From: McKernan, Patrick (NE) [REDACTED]
Sent: 28 January 2016 12:51
To: Simon Davis; Daniel Vick; Planning.Responses
Cc: Marlow, Angela (NE)
Subject: Natural England response to Pagham Harbour managed breach application

Date: 26 January 2016
Our ref: 173639
Your ref: P/97/15/PL

Planning consultation: Managed breach of shingle spit & blocking of adjacent tidal inlet channel with shingle barrier. Formation of shingle island within Harbour following excavation of adjacent area of spit.

Location: Pagham Harbour West Sussex.

Block Plan Showing the Breach and Infill Area

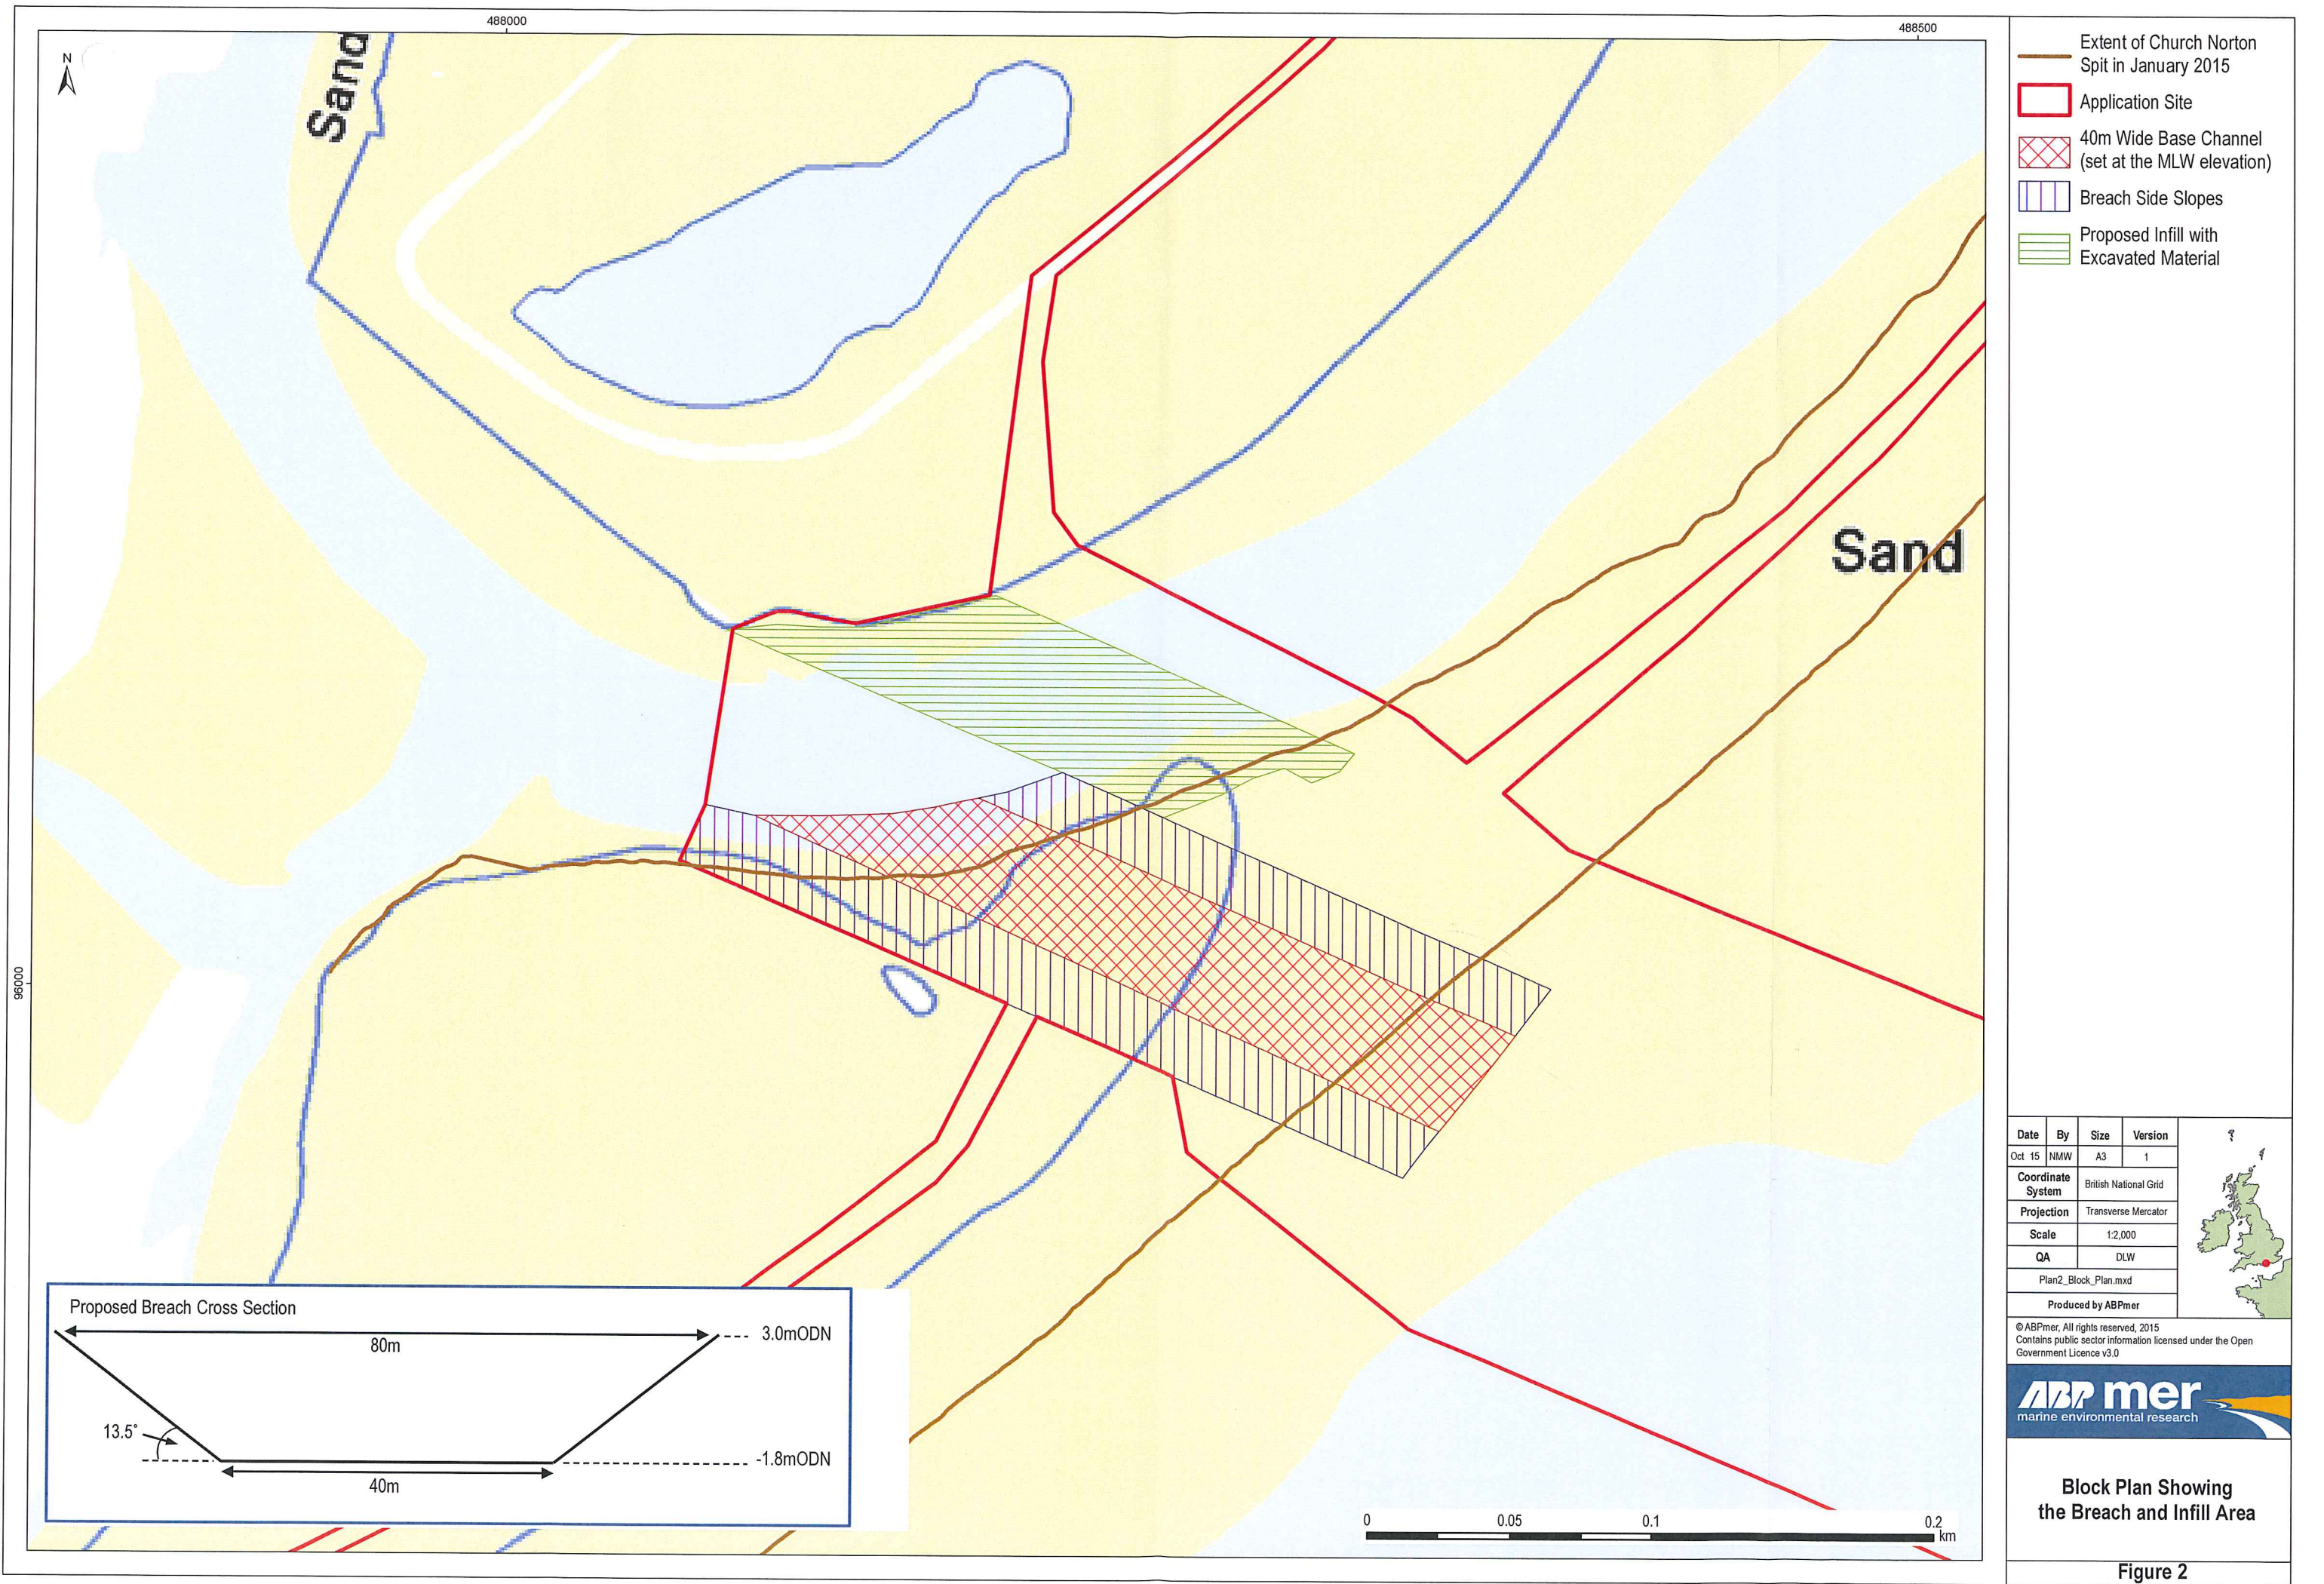
The current proposal for mitigating any closure is that the breach will be re-opened, but only once, and there is no proposal put forward to address any subsequent closure. We think that if the harbour remains closed for a substantial period there may be a significant adverse impact on the SPA/Ramsar site (and SSSI / MCZ) and either further measures would need to be put in place to remedy subsequent closures or additional evidence on the likelihood of this.

**Block Plan Showing the
Proposed Compensation Area
(‘New Tern Island’)**

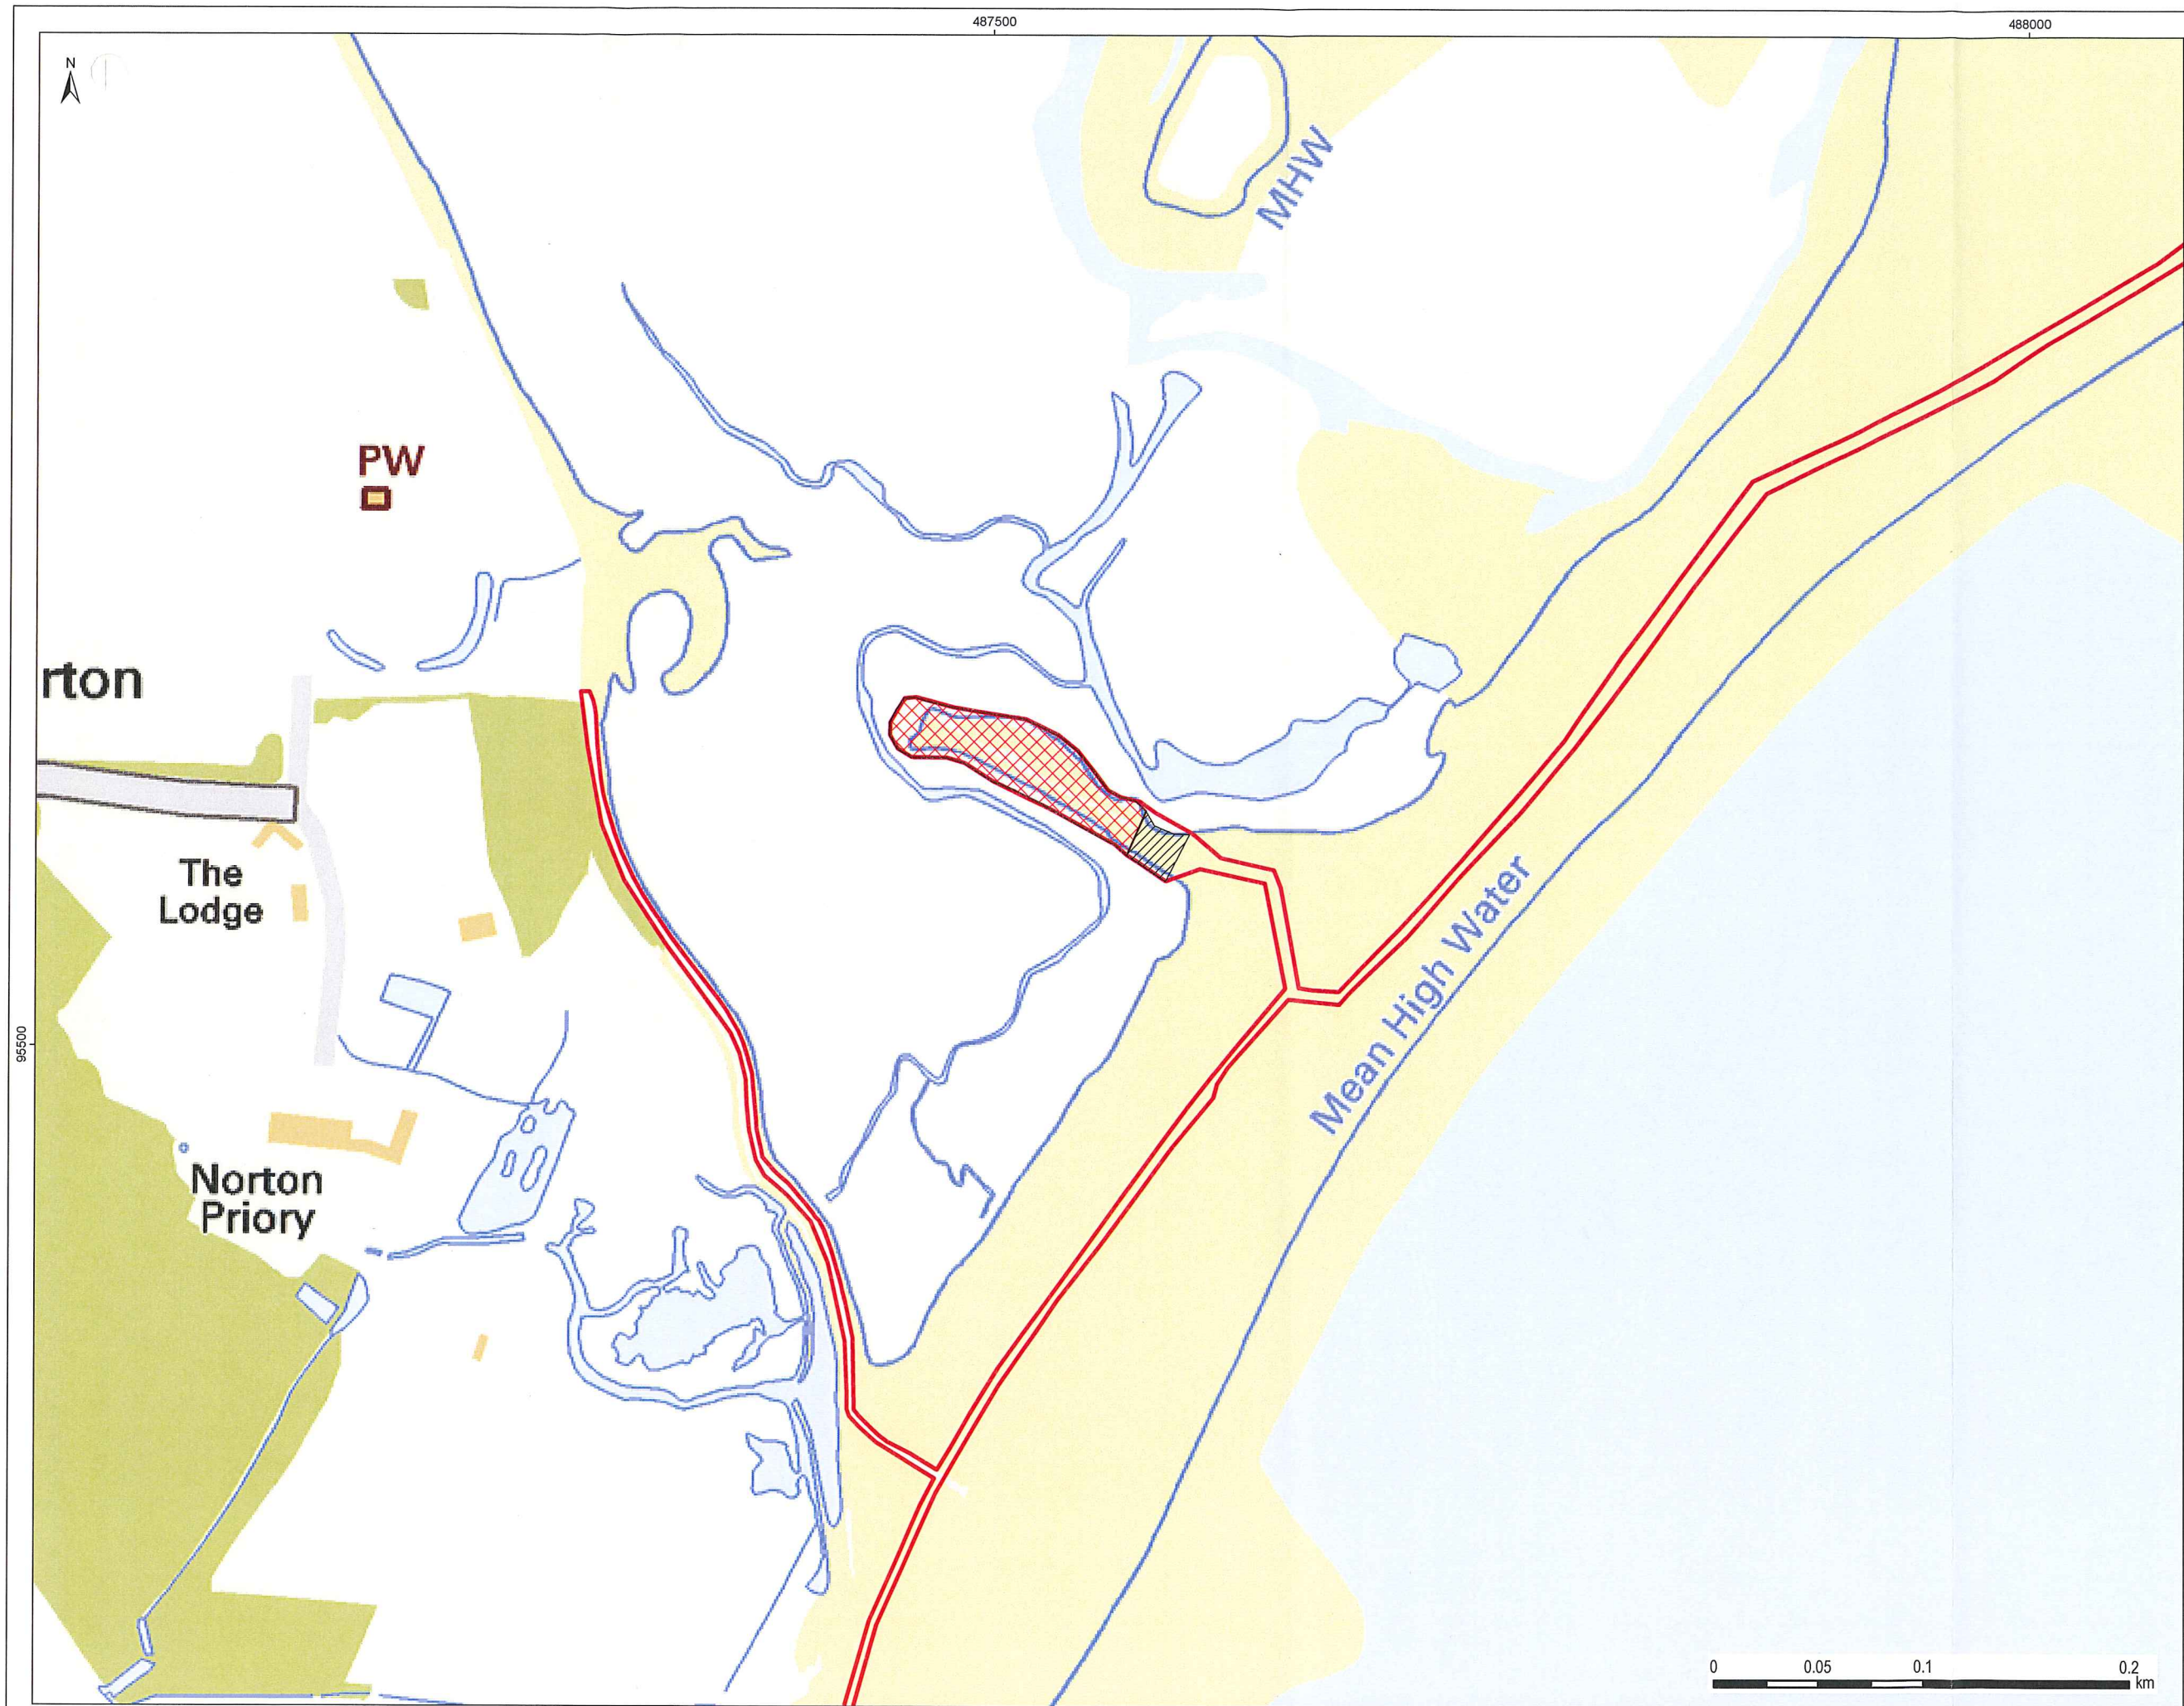
We suggest that the proposal for creating new little tern breeding habitat within the site, to replace the current breeding sites on the spit could be developed further. This will help to increase confidence that the potential impacts can be successfully addressed. Our view is that wardening procedures during nesting periods would also need to be robust to reduce the impact of potential increased disturbance. This project should work with the EU-funded LIFE+ project being implemented by the RSPB with an aim at Pagham Harbour to have a breeding colony of more than 20 pairs to increase confidence in the proposed mitigation measures.
